Subject: FW: LU/49/20/DOC - Former Windroos Nursery, Worthing Road, Littlehampton, BN17 6LY - Stage of Development Discharge

With regard to the remainder of the site where groundworks (including soft landscaping) have been completed, it is understood that the made ground was removed, although the total depth of excavation is not clear. In order for EH to be satisfied that these parts of the site do not pose an undue risk to human health, please may the developer and/or their consultant confirm whether the excavation of made ground removed any of the natural strata and if so, to what depth(s). If it did not, was any sampling undertaken to ensure that the natural strata were not contaminated by the overlying material?

However, please find my response below in red to the comments raised on 2nd April 2020 by the ADC Environmental Health Department:

AREAS VIEWED ON 21/1/20

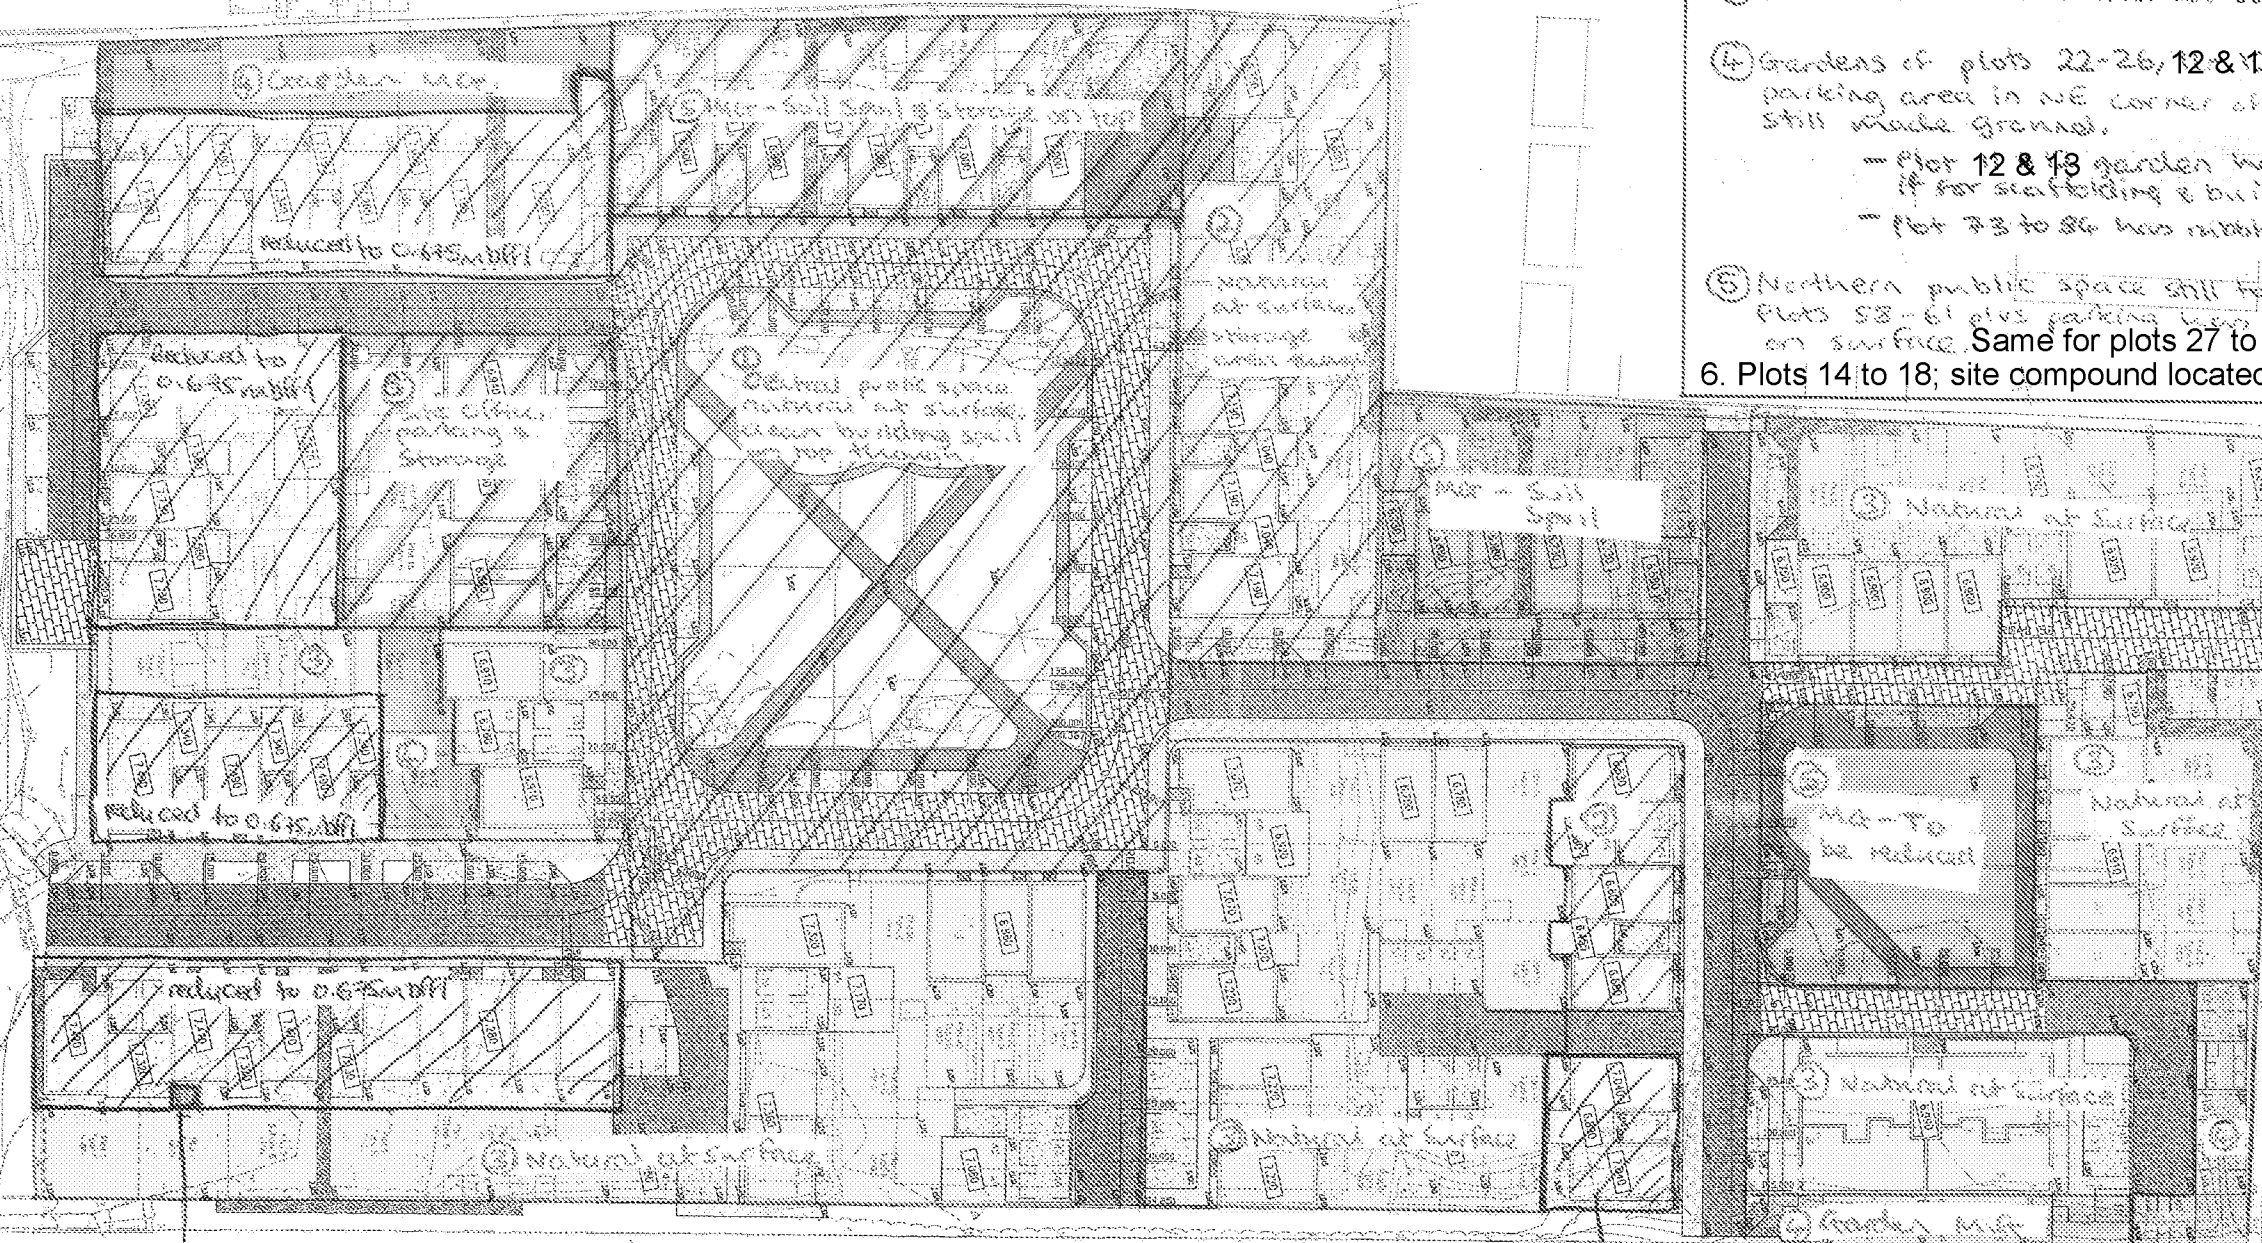
2. validation inspections of plots 14-18 are to be conducted

2. **validation inspections of the communal area to the north of the site are to be conducted**
 1. Similar to Plots 14-18, this area was being utilised for construction activities and the area was inaccessible at the time of all of WYG's visits. This is the one part of the site, which is not constrained in terms of below ground drainage or above ground structures, hence it was used and remains to be used as a material storage area for excavated material from roads, drainage and foundations.

WYG confirmed that the formation level over the full extent of the landscaped area was at virgin ground i.e. proposed garden levels minus 600mm was clean clay and identified on the verification plans. This can clearly be shown in the photos within the report. The site investigation identified Made Ground to be the source of contaminants. With no Made Ground visible and fresh excavation cutting into the virgin clay, there is no requirement for testing of materials that was not identified previously as contaminated and without visual or olfactory evidence of potential contamination. Testing of the virgin clays does not form part of the Remediation Strategy Report and page 6 clearly states: "In areas of the site where Made Ground is absent, no risk management procedures are considered necessary".

2. Following the demobilisation of the compound, the ground can be validated for Plots 14-18. However, all other plots should receive a discharge of condition on the basis that the remediation works have been completed and they can therefore be occupied.

2. As per Plots 14-18, we are aware that this area needs to be confirmed but can only be done so once it is no longer being used for construction purposes. However, all other plots should receive a discharge of condition on the basis that the remediation works have been completed and they can therefore be occupied.
